Town & Country Planning Act 1990 (as amended)
Town & Country Planning (Development Management Procedure) (England) Order 2015
Application for Planning Permission for Works or Extension to a Dwelling

Development Proposed ground floor rear extension, internal redesign and all associated works at 34 Warren Crescent.

Location 34 Warren Crescent East Preston

DRAWING TITLE
EXISTING AND PROPOSED BLOCK PLANS

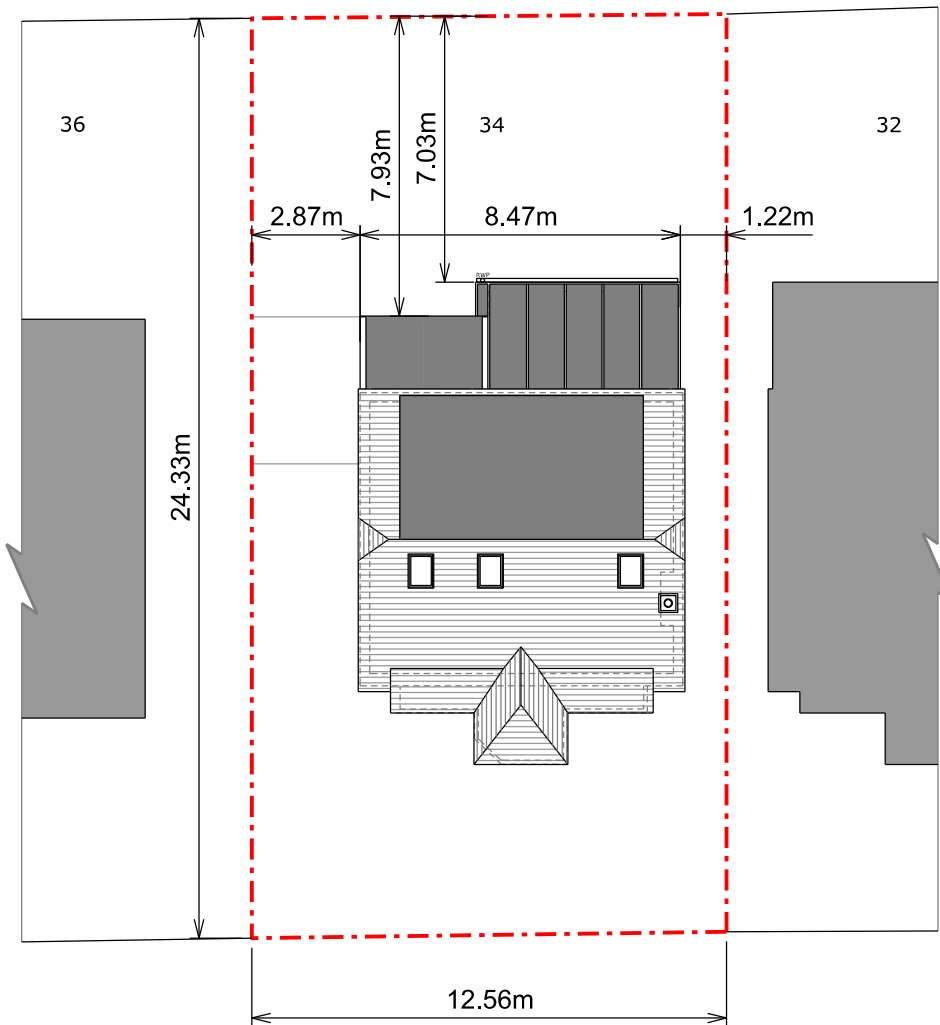
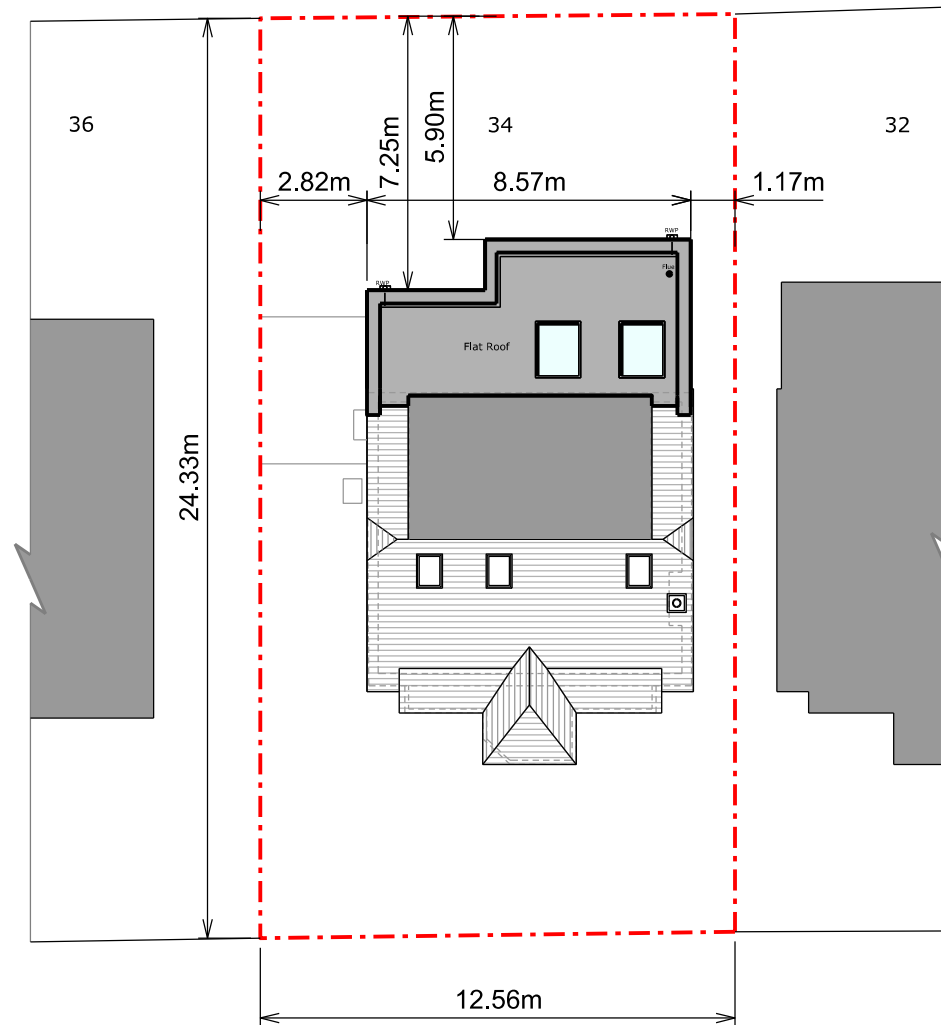
Block Plan

Please include dimensions on your block plan from the proposed extension to all site boundaries.
